C18D101

Project Title: SILVER OAK SUBDIVISION lot 6 Building Permit #: _____ City Drainage #: C18D101
DRB#: 1010644 EPC#: _____ Work Order#: _____
Legal Description: SILVER OAKS
City Address: 8815 SILVER OAK

**RE: Drainage Resubmittal
Silver Oak Subdivision- (C18D101)
Albuquerque, New Mexico**

RE: Silver Oak Estates | Grading and Drainage Plan | Stamp 10-21-15 (File: C18D101)

ENGINEER'S SEAL	SILVEROAK ESTATES	DRAWN BY WCVJ
	MASTER UTILITY PLAN	DATE 12-18-15
	 Rio Grande Engineering 1806 CENTRAL AVENUE SUITE 201 ALBUQUERQUE, NM 87106 (505) 872-0999	21525-LAYOUT-9-28-15
DAVID SOULE P.E. #14522		SHEET # 4
		JOB # 21525

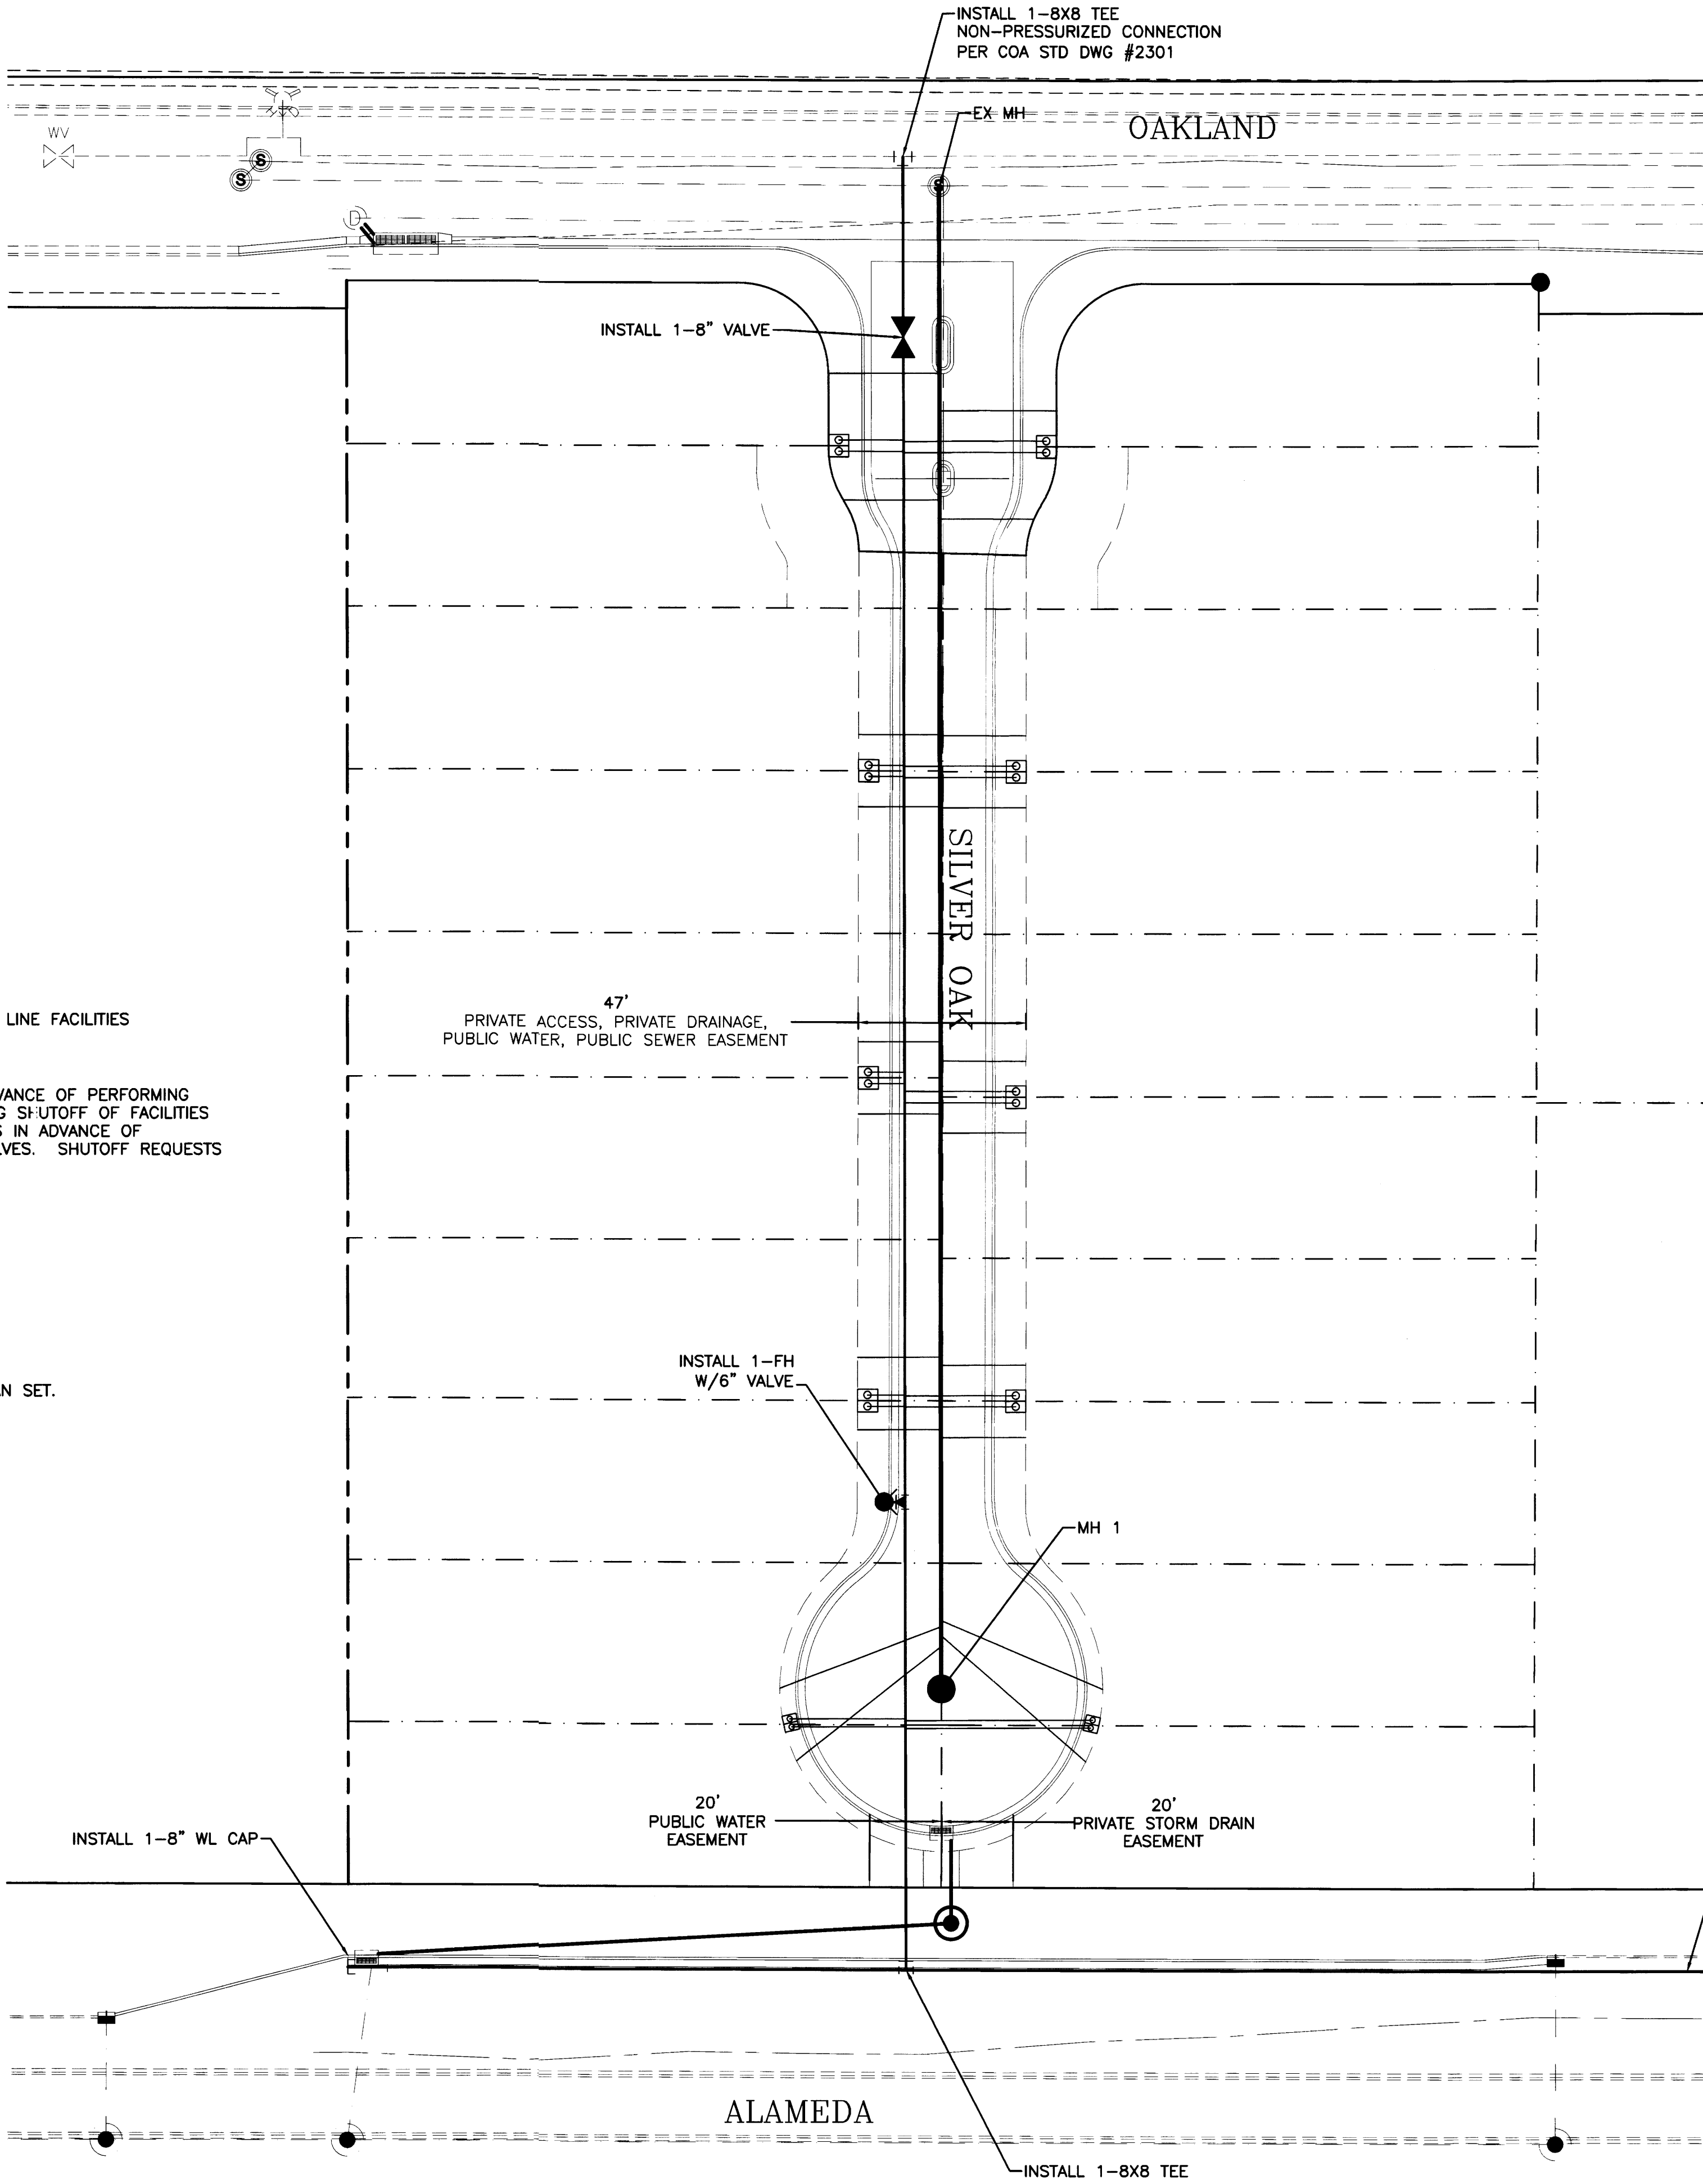
1. Clarify the easement dimensions between the cul-de-sac and Alameda Blvd. The Utility Plan shows a different layout than the Site/Grading Plan.
2. The inlet at the end of the cul-de-sac bulb appears to conflict with the intent to have an access easement to the southernmost lots.

1. Clarify easement dimensions between cul-de-sac and Alameda
We have corrected the preliminary plat. There are three easements, one is a 20' private drainage easement on the east, a 20' public water line is on the west and a 10' private access easement straddles the two. The access easement is for pedestrian connectivity to alameda. It also serves as an emergency overflow.

GRADING AND DRAINAGE PLAN

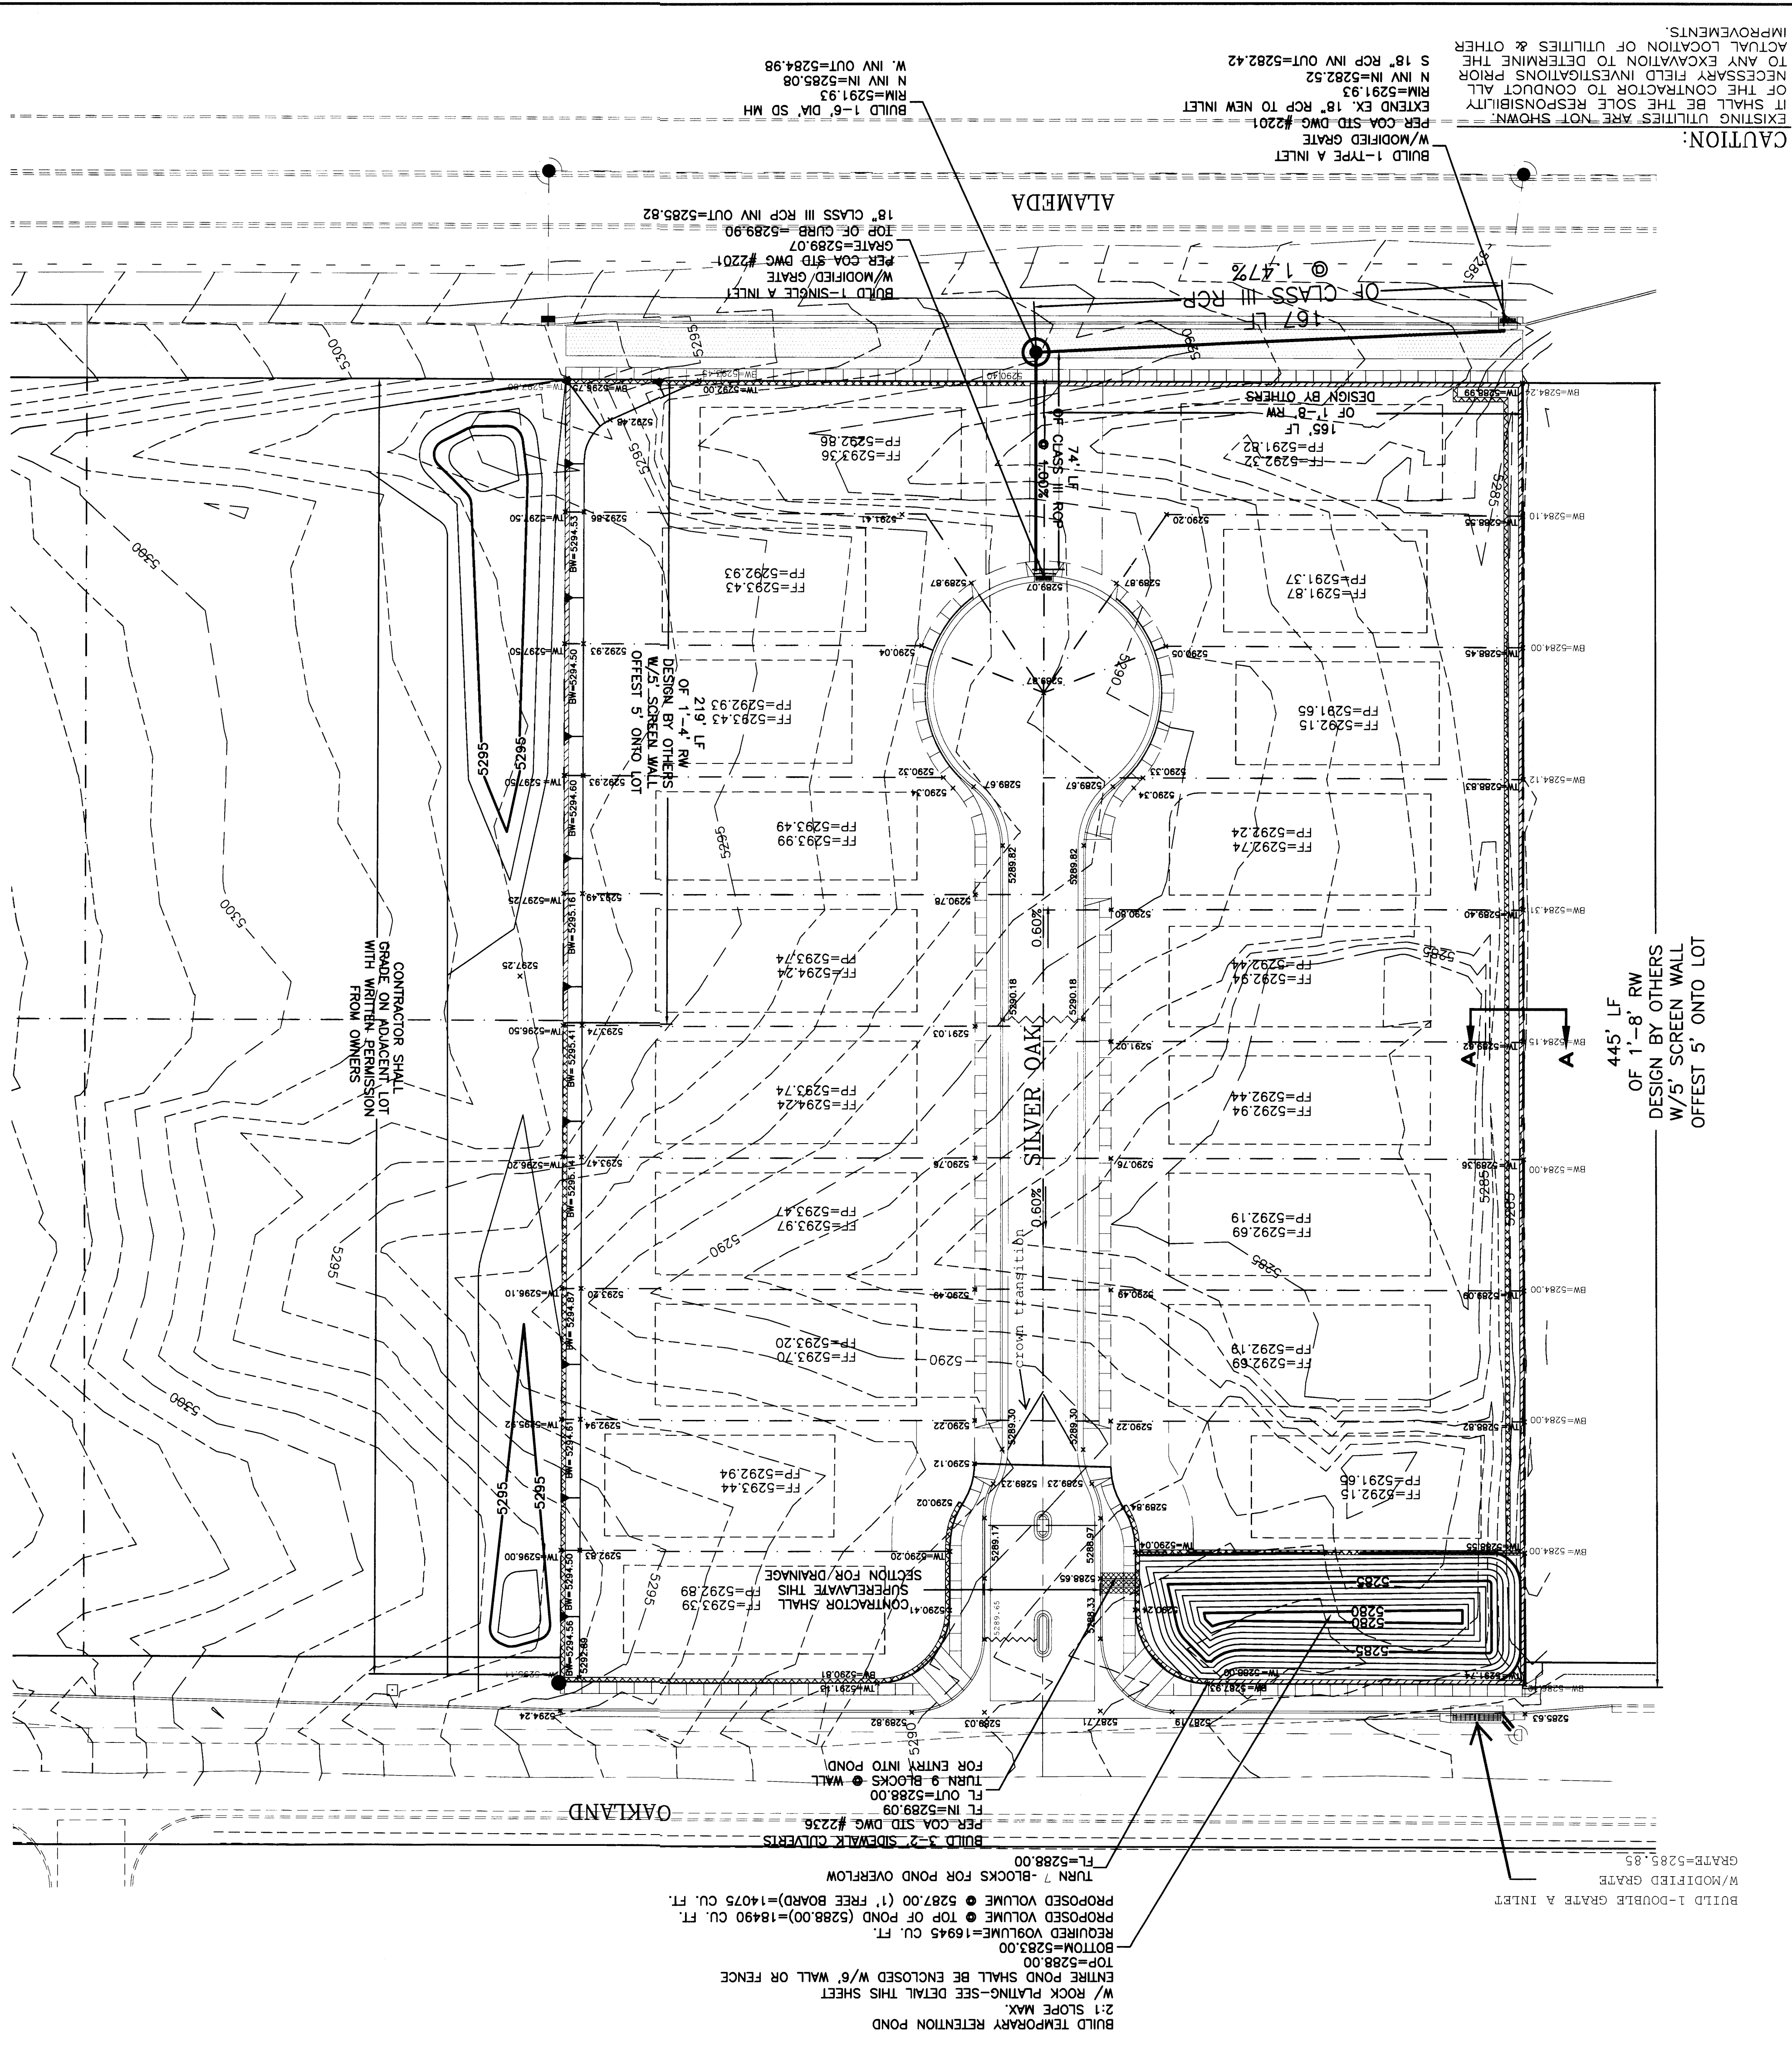
3. At the entrance, there is a low spot on the northbound side curb and gutter; it appears that the intent is to convey flows west into the temporary pond. The plan should clarify to the Contractor that the crown of the road is to be warped so as not to create a sump.

5. Show the emergency spillway for the pond as referenced in the drainage report.
6. Call out the wall opening that will be needed to convey flows into the pond.

7. Show elevation points at the rear lots that show the intent to install rear lot ponds.
 - a. The rear and front yard ponds and typical lot layout showing the first flush ponds should also be shown on the landscaping sheets, since it appears that the fine grading of those facilities might be completed with the installation of graveling and plantings, not with the grading of the lots.

3. Correct low spot at entrance
We have provided a transition for super elevated roadway to provide water block to Oakland as well as allowing onsite water to be captured by the temporary pond. The detailed road profiles and median flow lines at DRC will assure proper flow. We have eliminated the low spot.

5. Show emergency overflow
We have modified the contours to identify the overflow. We have labeled the turned blocks at the wall. Since this is an emergency overflow for a temporary pond we are not proposing culverts. We have included the capacity calculation for each turned block. The pond inflow is 6.89 cfs and each turned block has a capacity of 1.04.

6. Call out wall opening
We have placed build notes for the wall openings.
7. Show elevation points at rear yard pond, landscape plan should show front yard pond
We have added a typical section for the rear yard and front yard ponds. To add points to grading plan will make the document illegible. We have added pond to the landscape plans
